Fenwick Solar Project Limited

**Planning Act 2008 – Application for a Development Consent Order for Fenwick Solar Farm**

**Applicant Response to Section 51 Advice Letter dated 29 November 2024**

**Application Ref: EN010152**

Access 4  
off Fenwick Common Lane  
Scale - 1:500

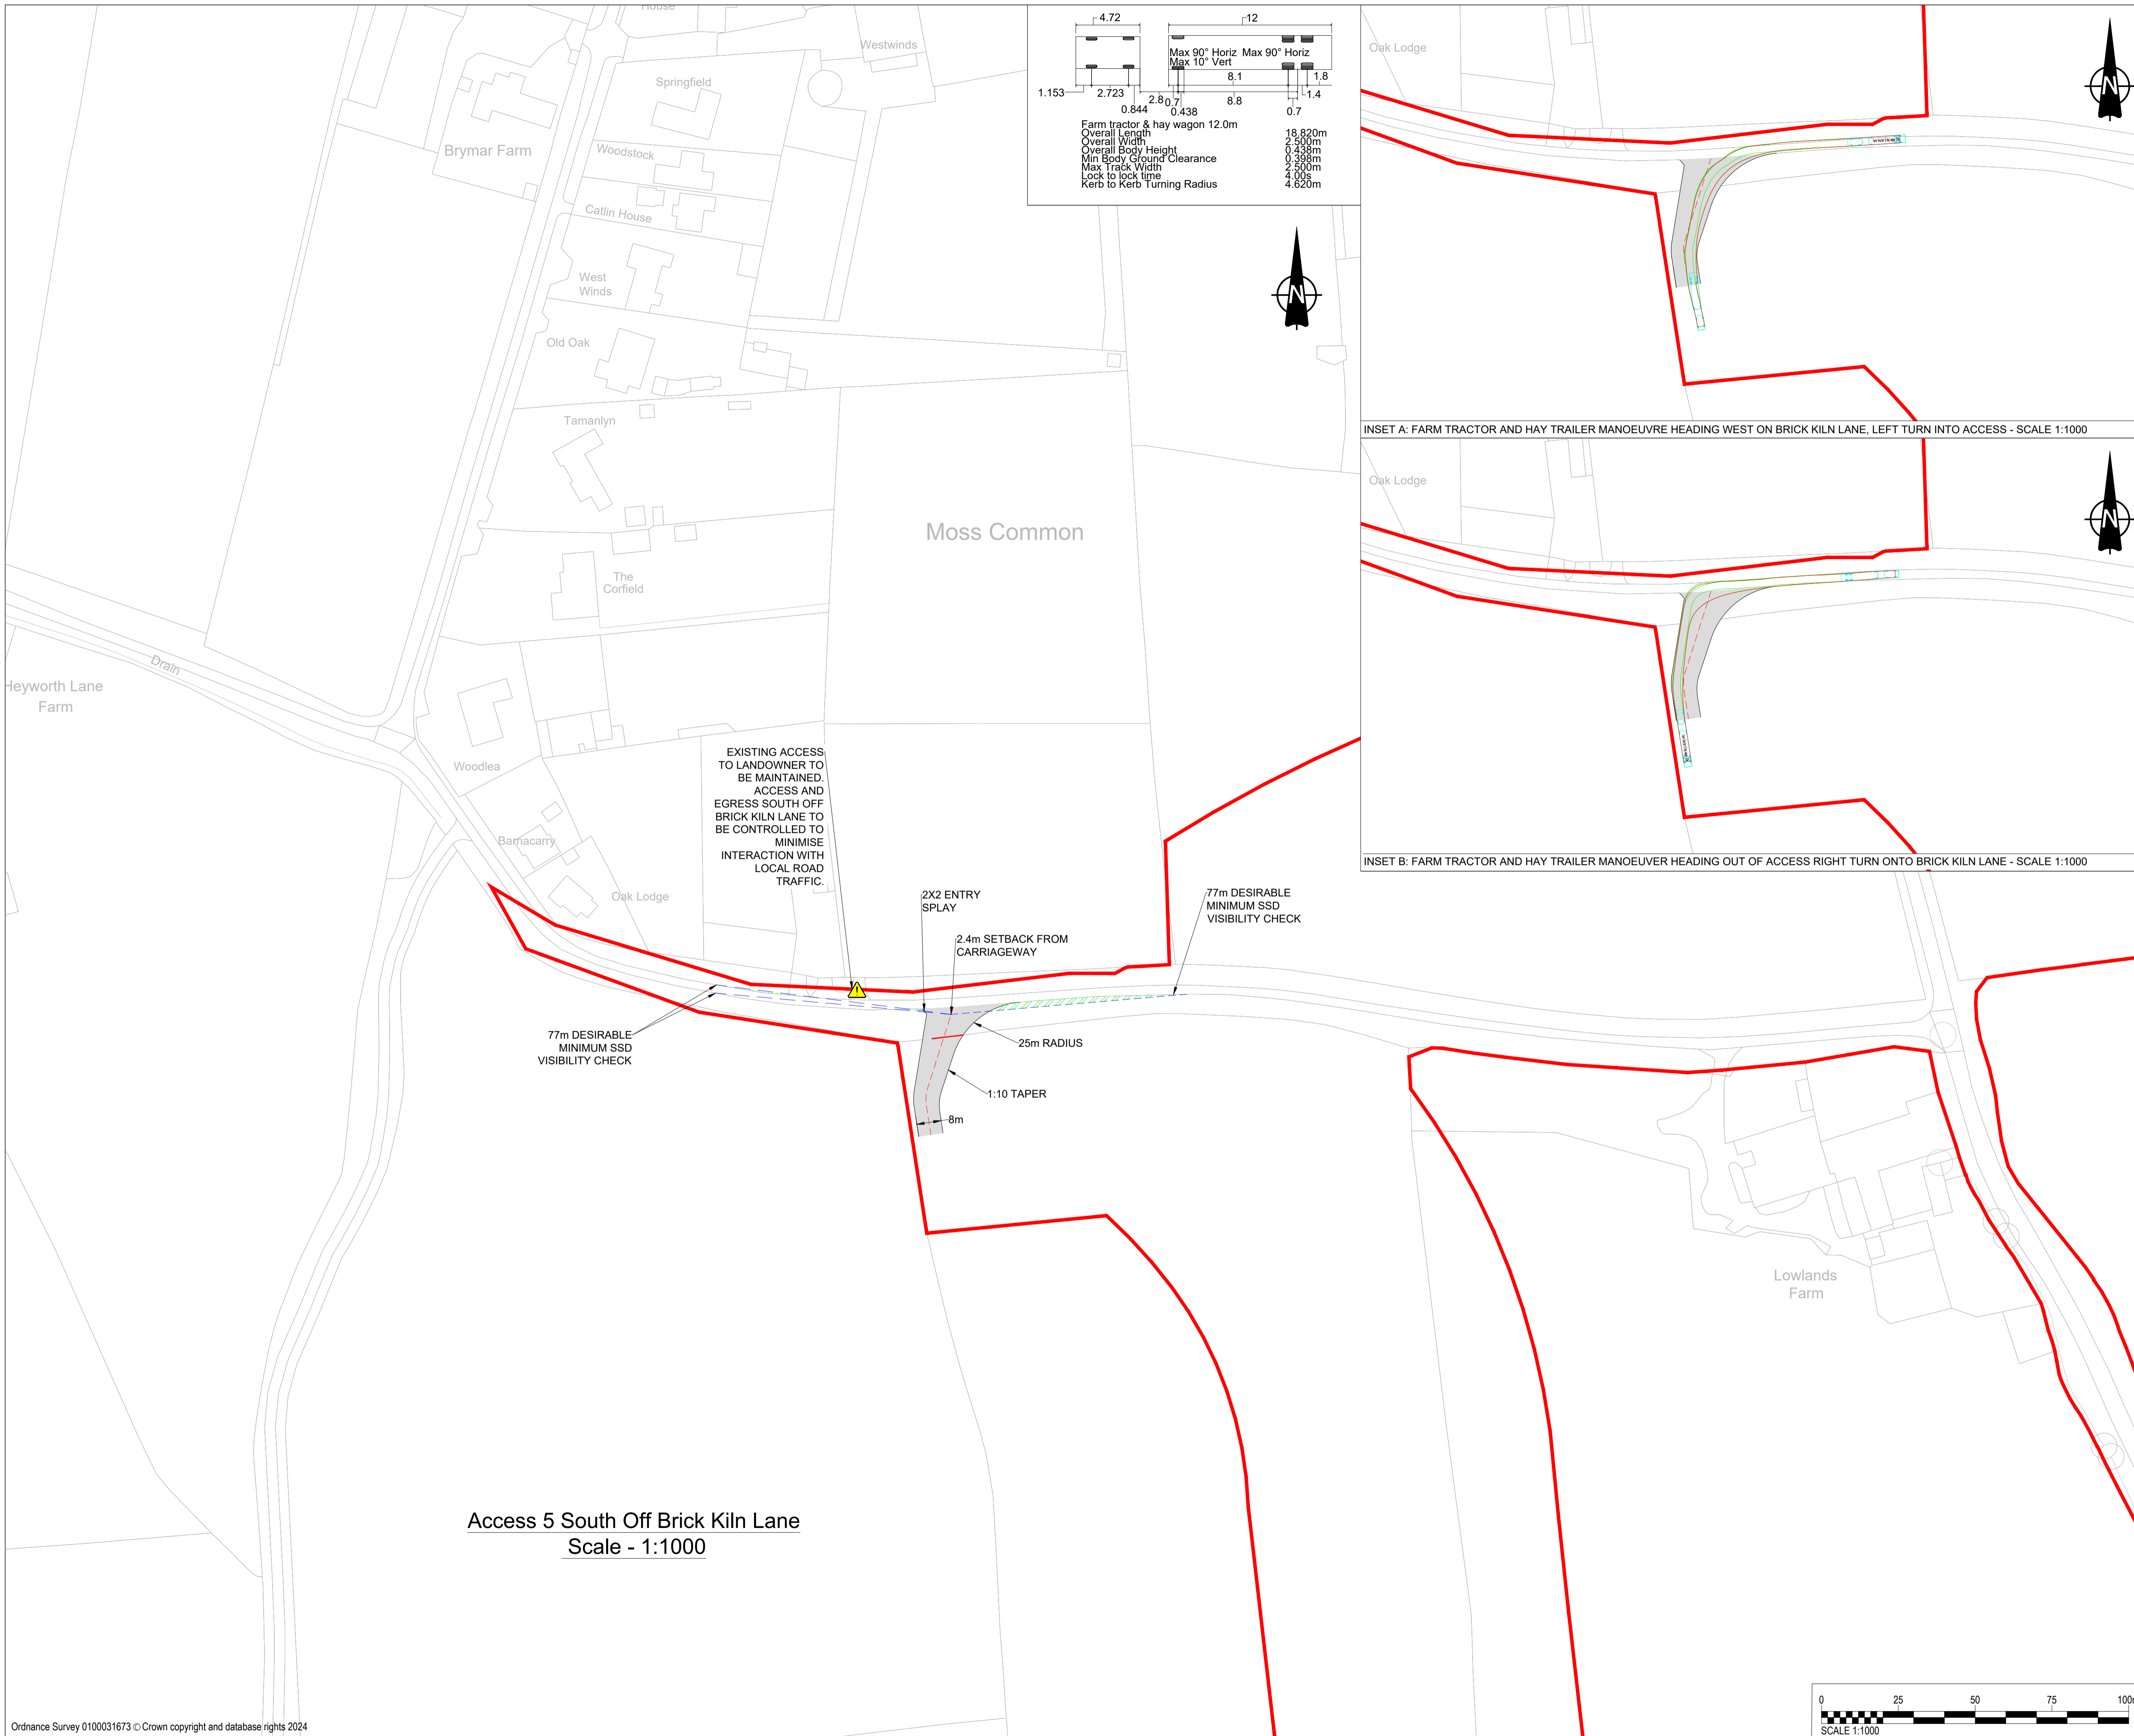
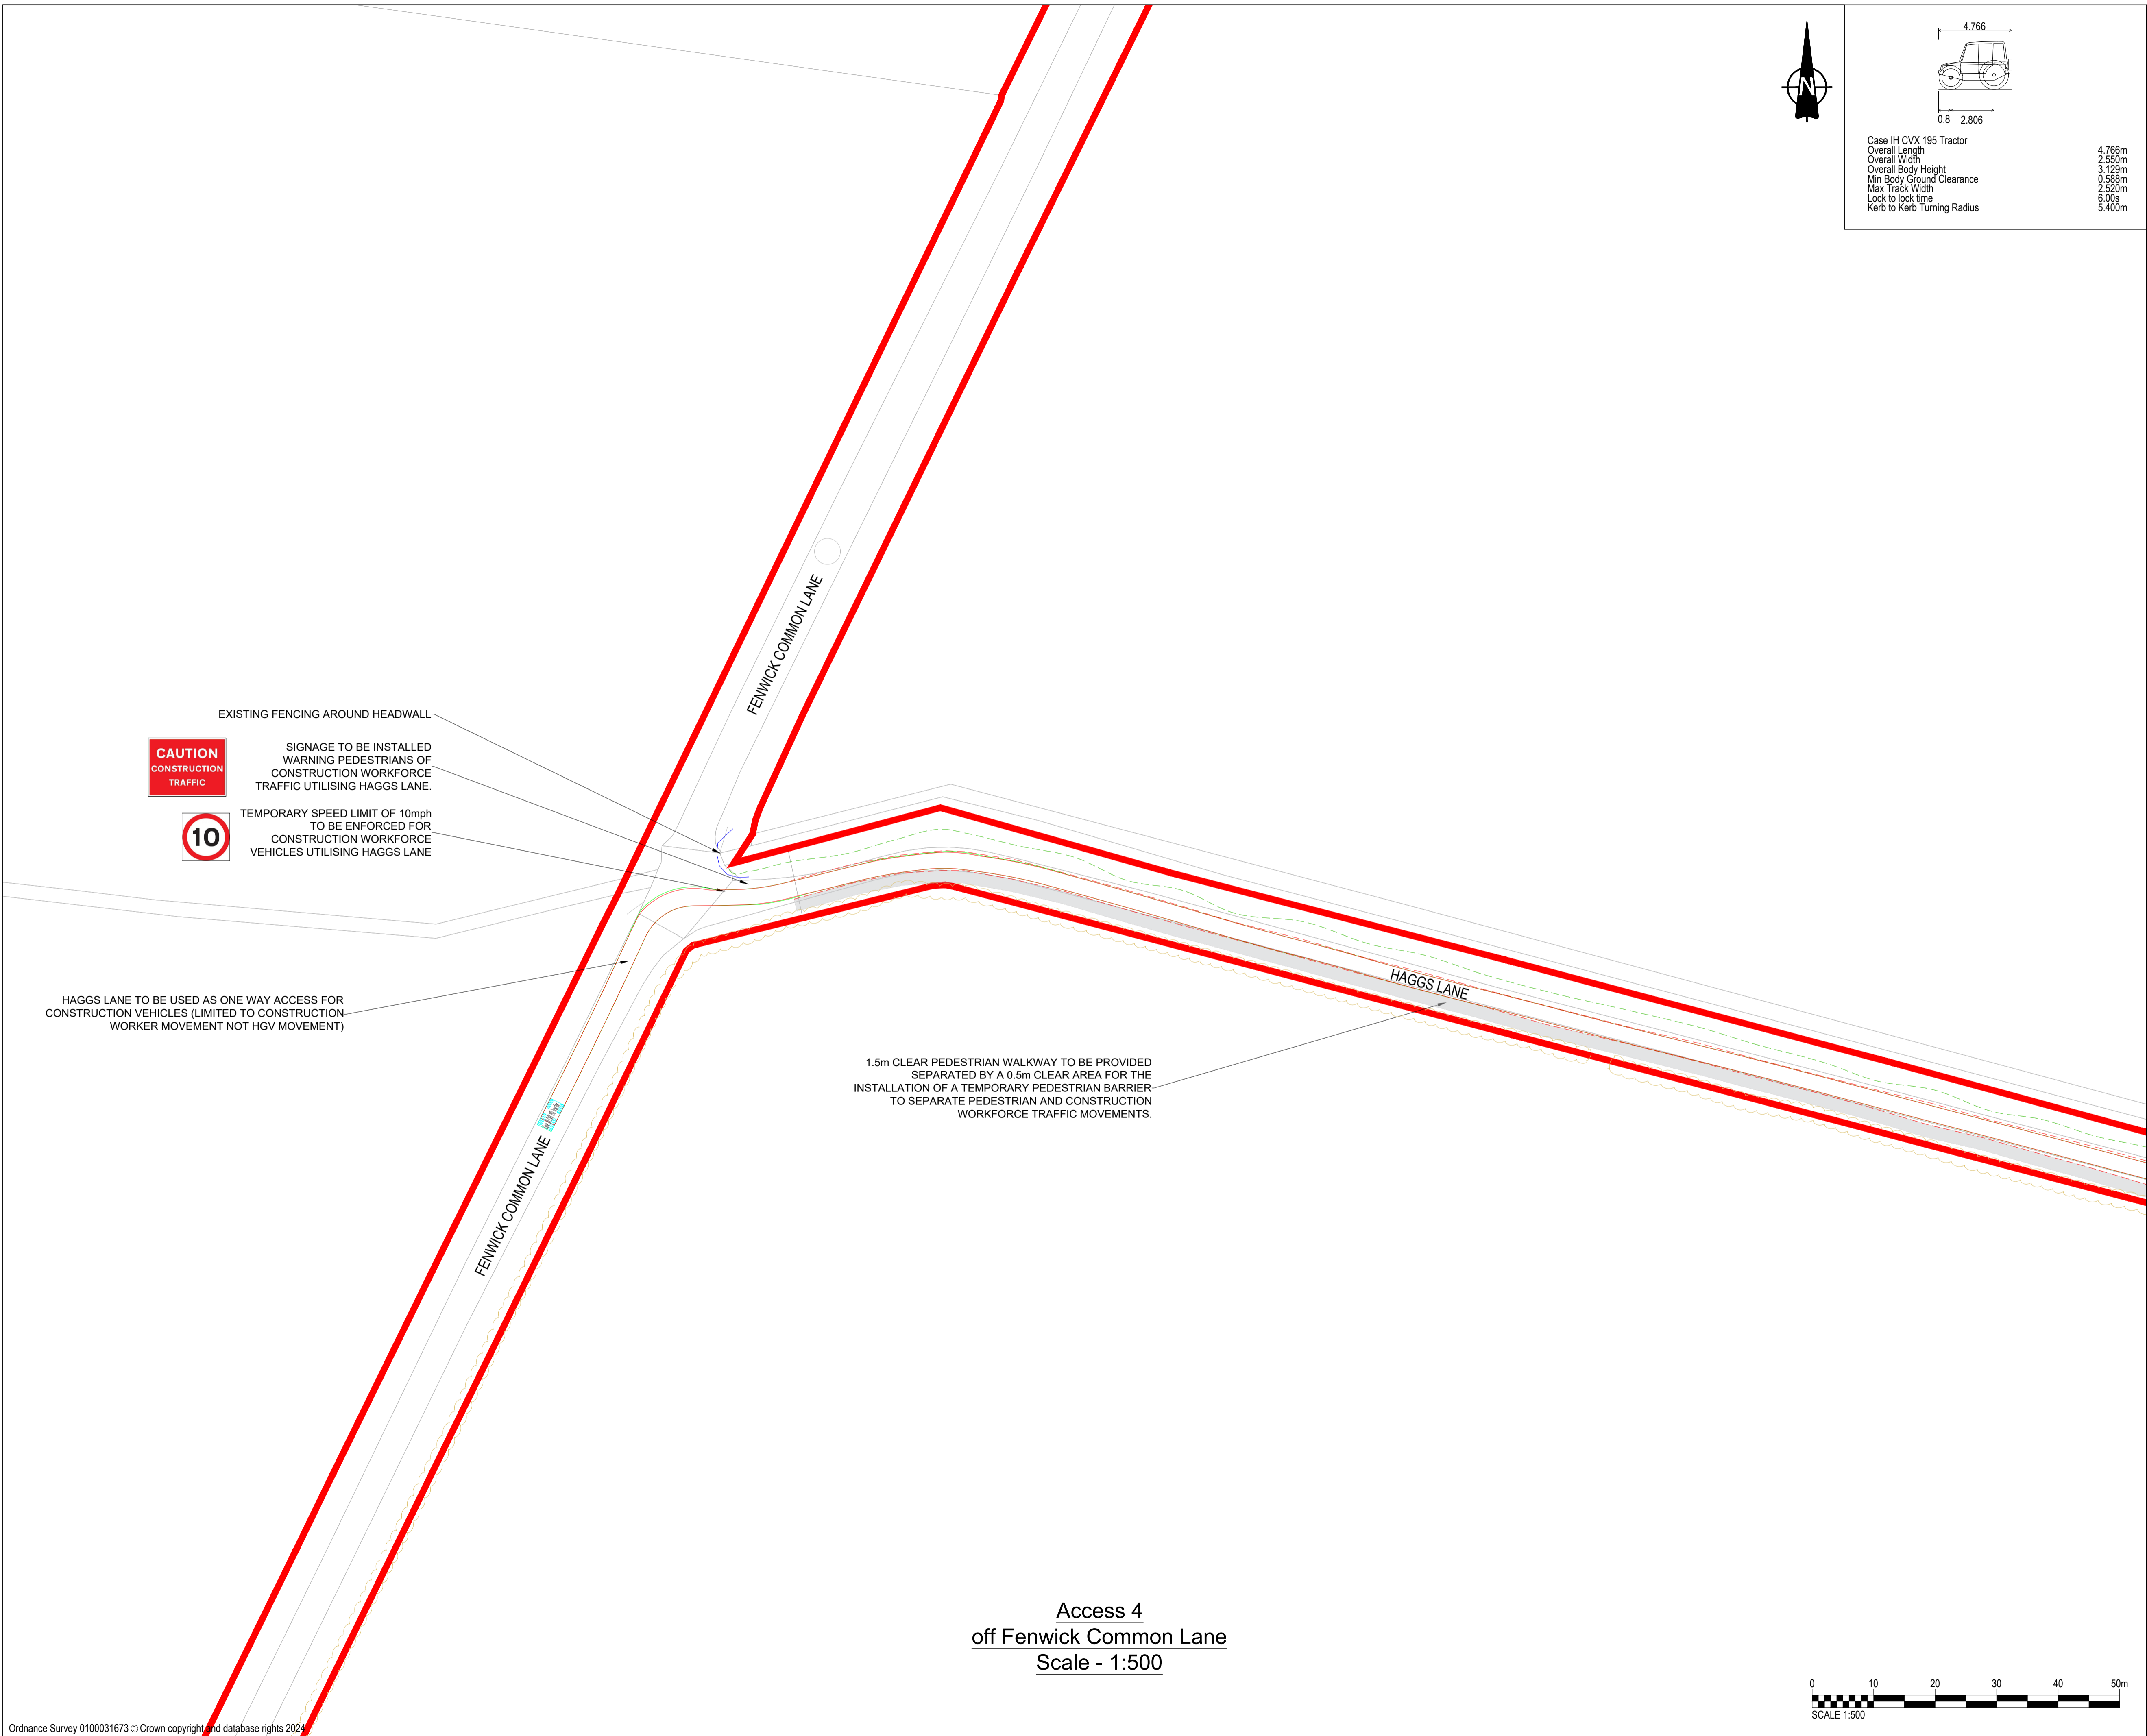
1.11.1 The access drawings contained in Appendix A of the **Framework Construction Traffic Management Plan [EN010152/APP/7.17]** have been updated to add the relevant road names and a new scheme wide access layout plan has been included.
